PHILIP HEARD IP NUMBER [REDACTED] : FOSSE GREEN DEADLINE 5A SUMMARY

Drawing file: published-documents / EN010154-000142-6.2 Fig 3-6B Indicative On Site Substation Elevation.pdf

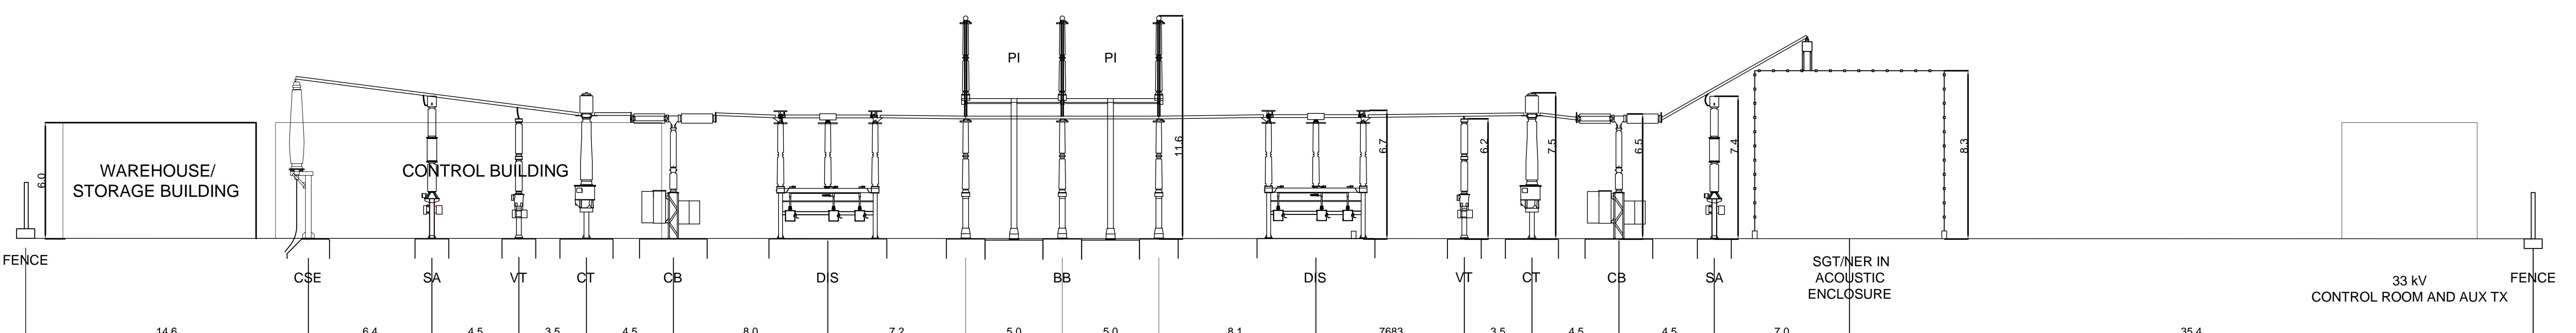
5. BESS Safety – Missing Worst-Case Scenario

The Applicant declines to model a **worst-case thermal runaway propagation event**, despite relying on the Rochdale Envelope elsewhere. This omission leaves a significant safety gap, particularly given recent UK BESS fires and the absence of evidence that the Applicant’s framework would prevent similar incidents.
